## KITTTITAS COUNTY COMMUNITY DEVELOPMENT SERVICES

May 5, 2008

Kittitas County Community Development Services has determined that the Duke Short Plat (SP-07-167) is a complete application and hereby grants **conditional preliminary approval** subject to the following conditions:

THE DUKE SHORT PLAT
KITTITAS COUNTY SHORT PLAT NO. XX-XX
PORTION OF THE SOUTH 1/2 OF THE NORTHWEST 1/4 OF
SECTION 25 T.20N., R.16E., W.M.
KITTITAS COUNTY, WASHINGTON

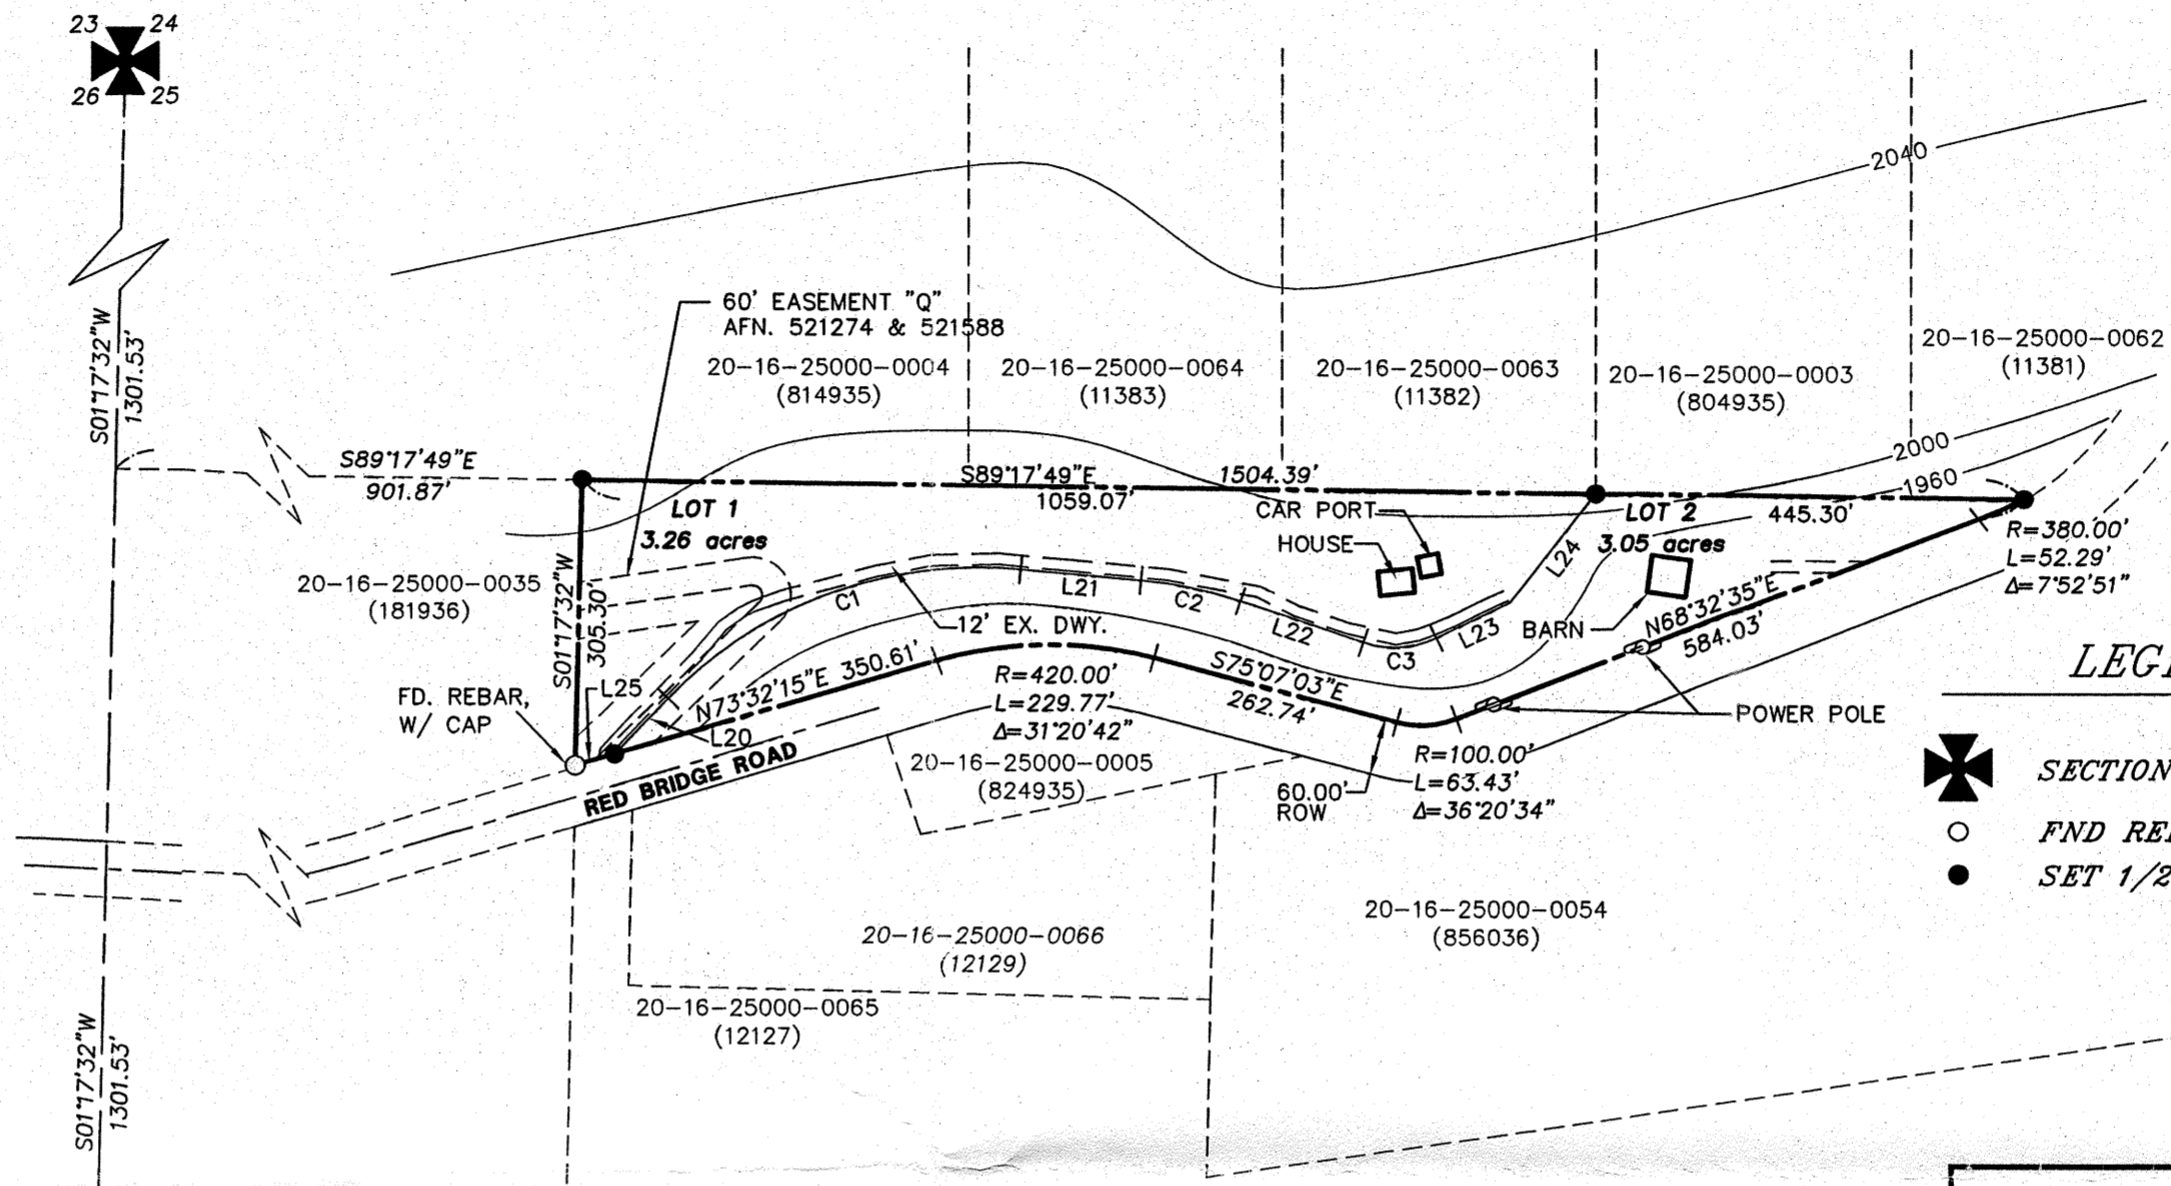
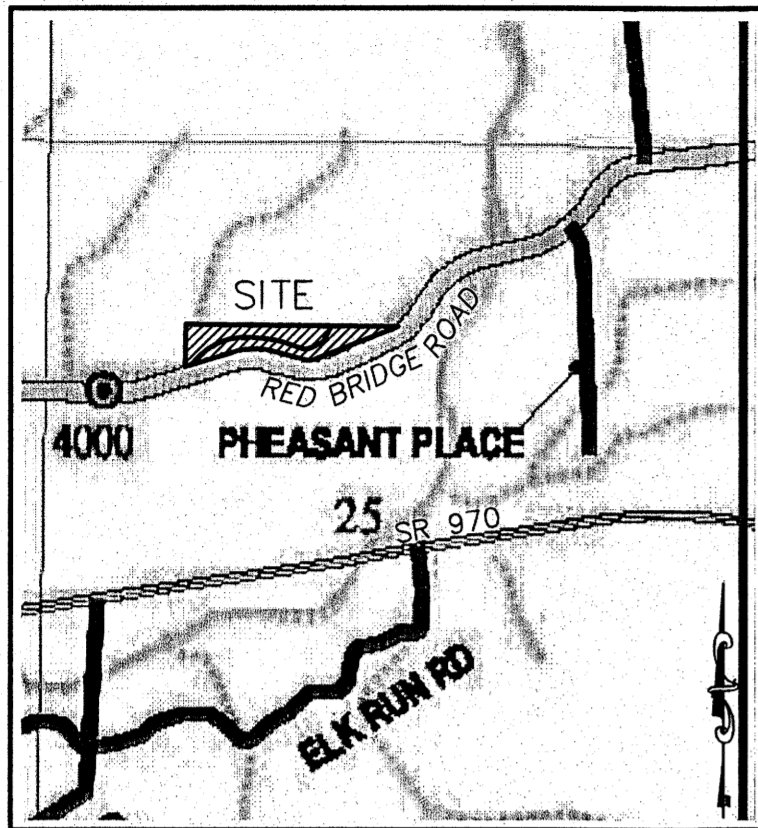
2. Full year's taxes must be paid for 2008 on all tax parcel numbers per requirement of the Kittitas County Treasurer's Office.
3. The well located on lot 1 shall be depicted on the final mylars.
